DECISION DELEGATED TO HEAD OF PLANNING

Application No: H16-0976-25 **Applicant:** Ms M Firth
Proposal: Erection of 4 detached dwellings - outline approval H16-0615-22
Location: Rear Of The Beeches Horseshoe Road Spalding
Terminal Date: 5th December 2025

Revision	Date	Drawn	Description
Client	Ms Mel Firth		
Project	Proposed Residential Development, Horseshoe Road Spalding		
Drawing	Planning Plot 1 (Elevations & Floor Plans)		
Scale	1:50, 1:100, @ A1	Drawn AWM	Checked TAC Date 09/10/2025

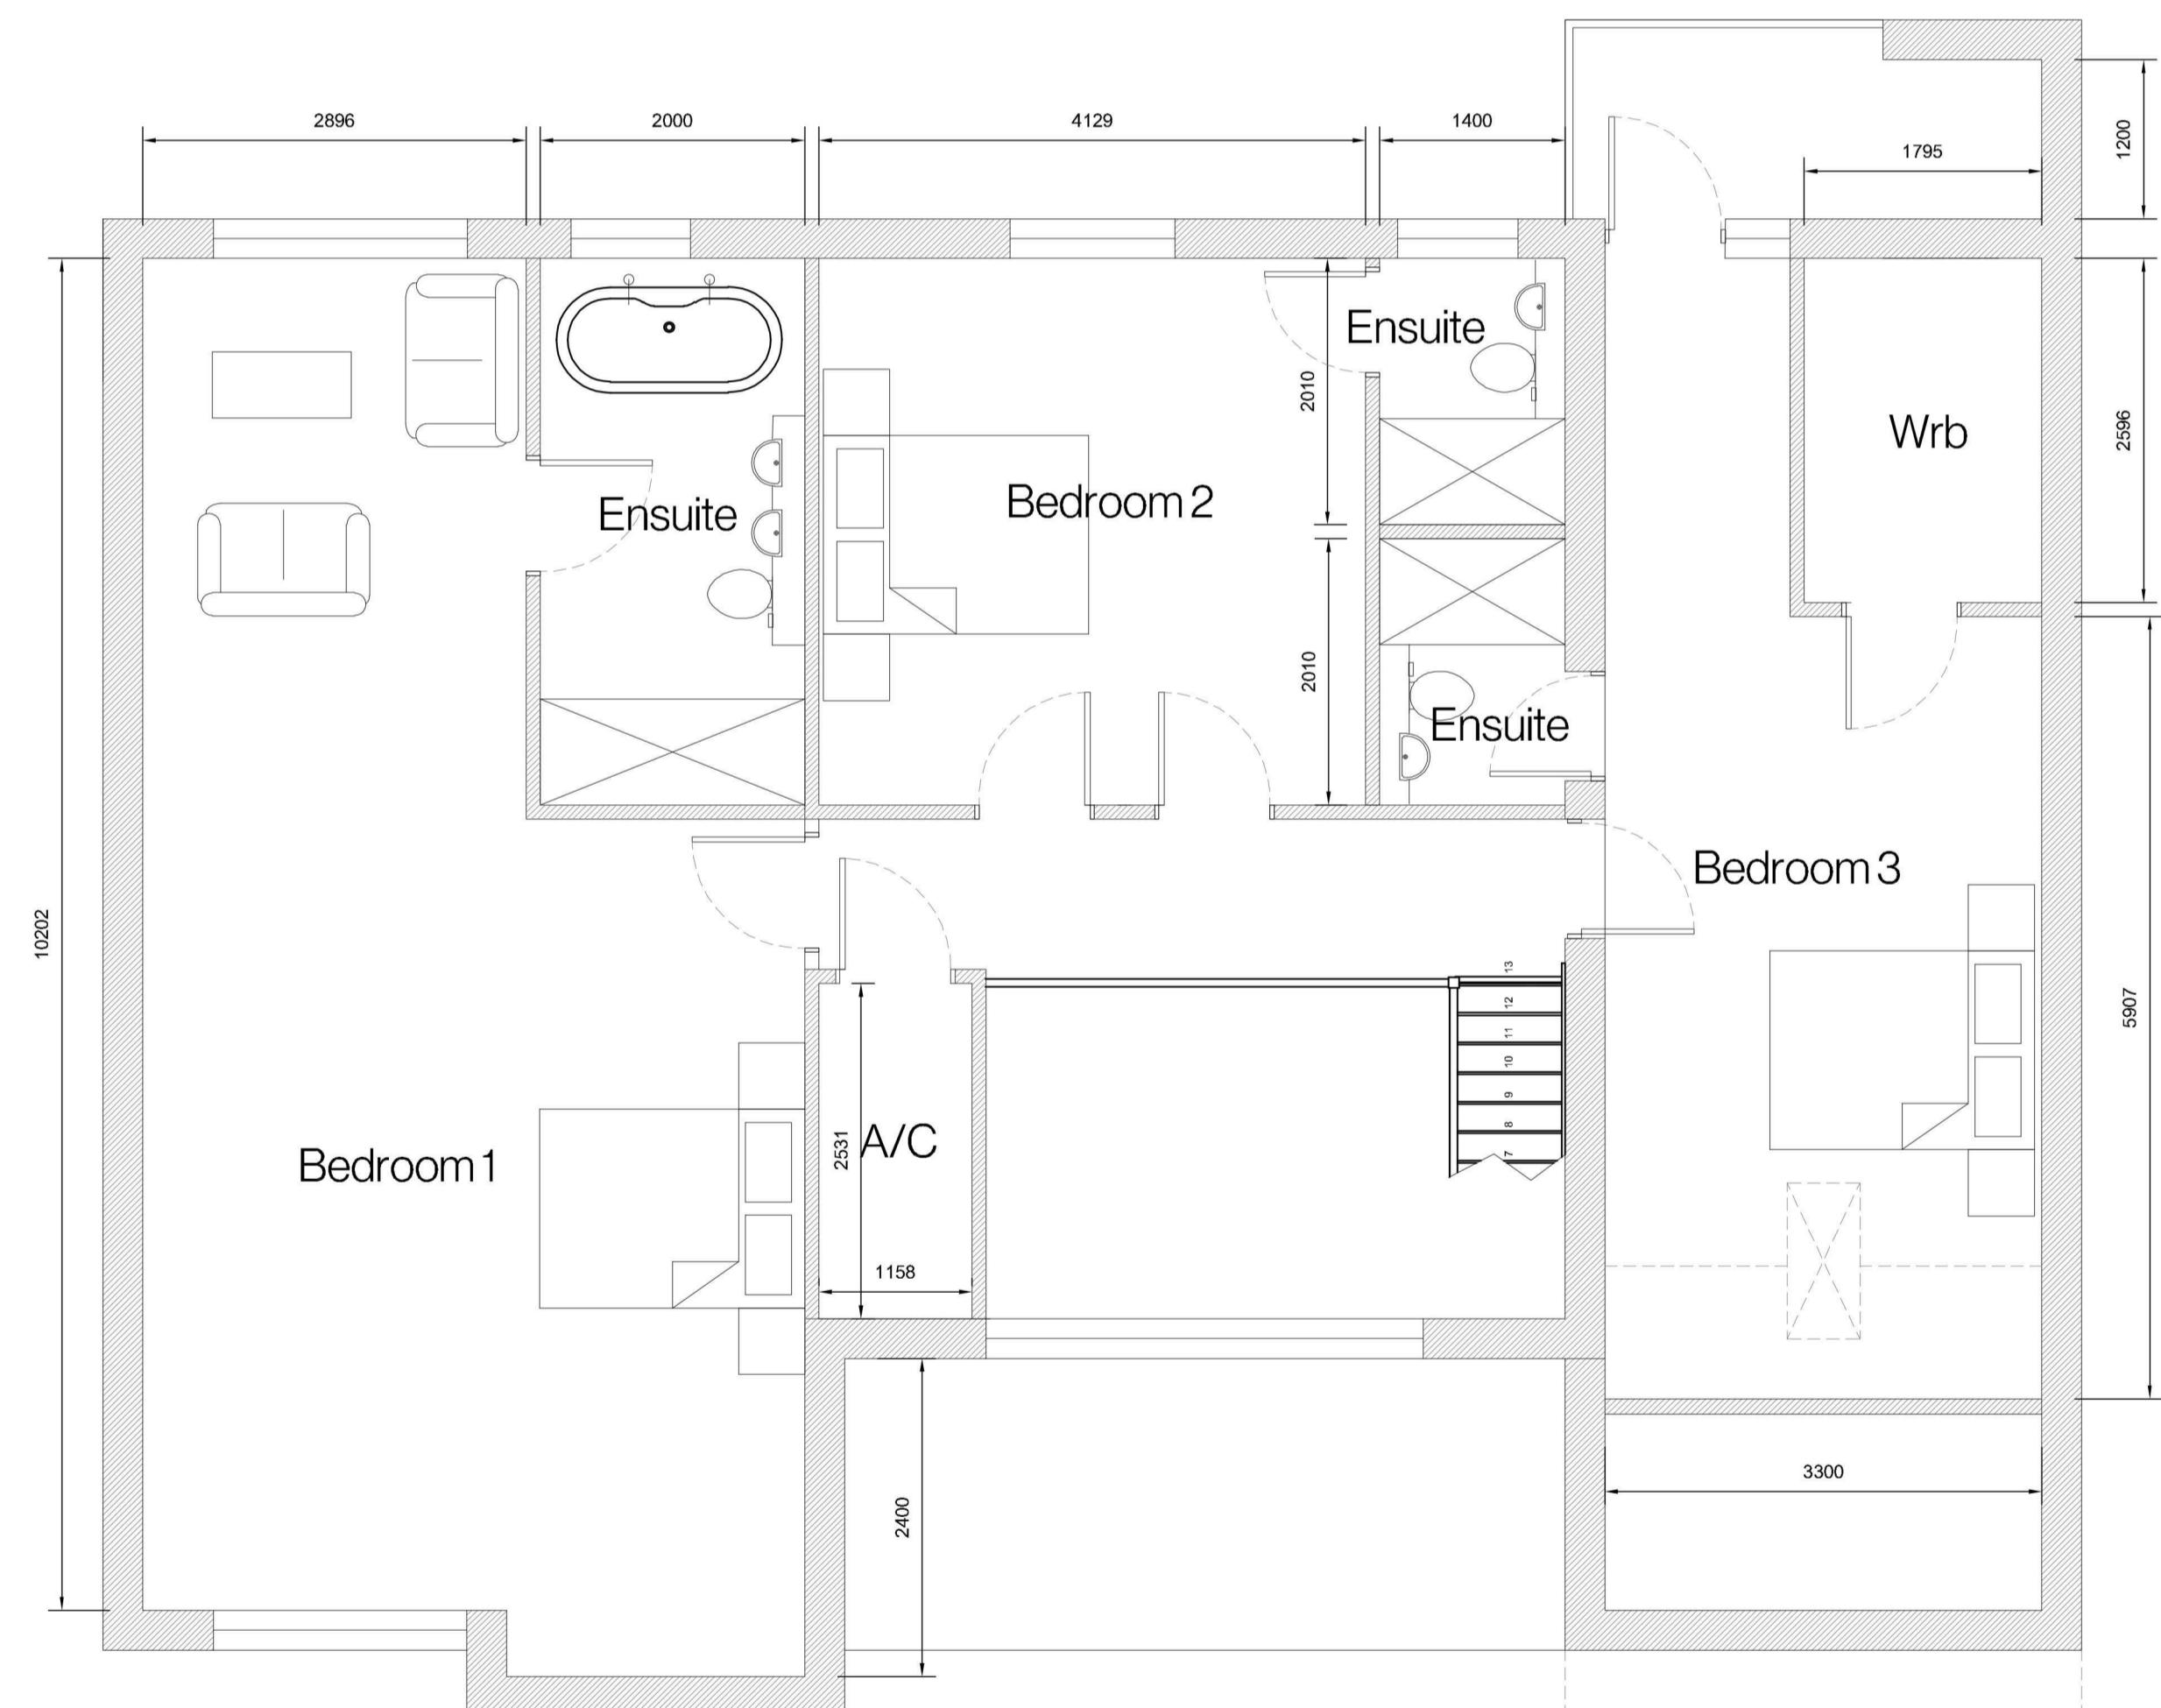
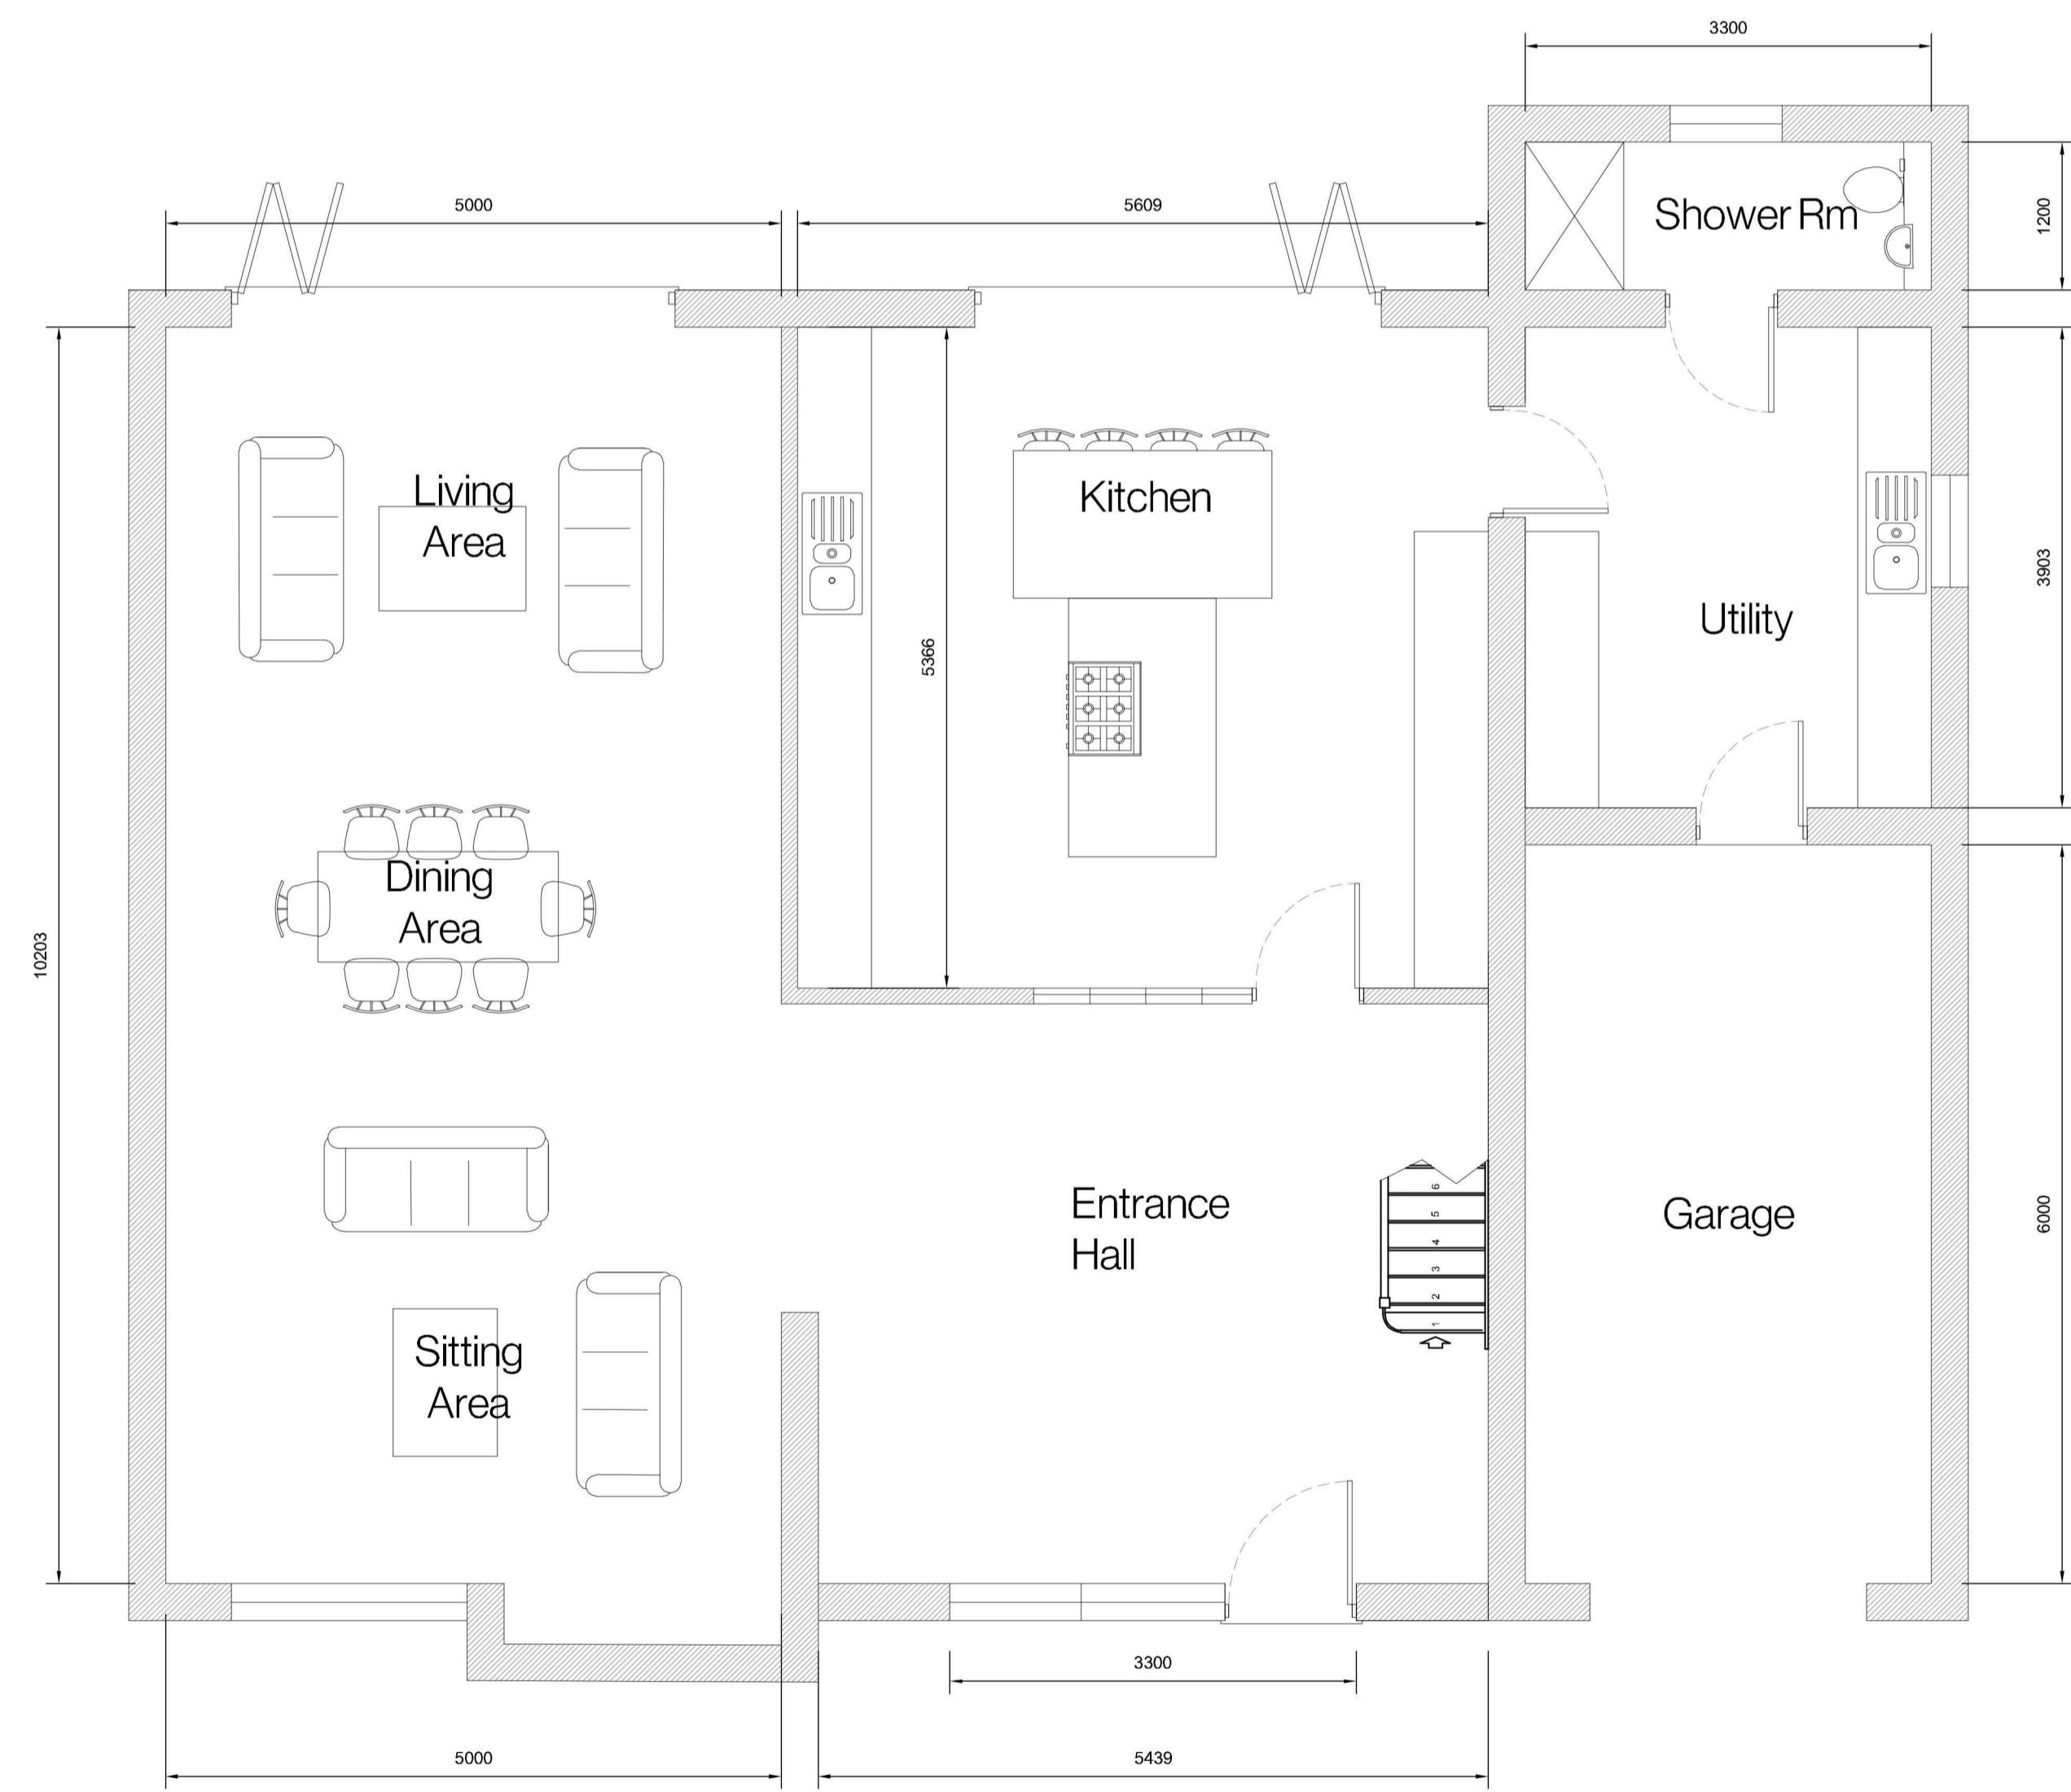
The proposed dwellings are of a significant scale. The Beeches, which Plot 1 sits behind is a bungalow. As a result, Plot 1 would be unduly dominant when viewed from Horseshoe Road, breaking the conventional subservient relationship between frontage and backland development. The result is an unduly dominant development, which directly conflicts with the established openness of the area. The relationship between Plots 1 and 2 vs 3 and 4 also furthers this perception, as Plots 3 and 4 are far larger than their neighbours. Moreover, it would exacerbate the perceived overdevelopment of a backland plot referenced previously in this report by creating a more dominant development.
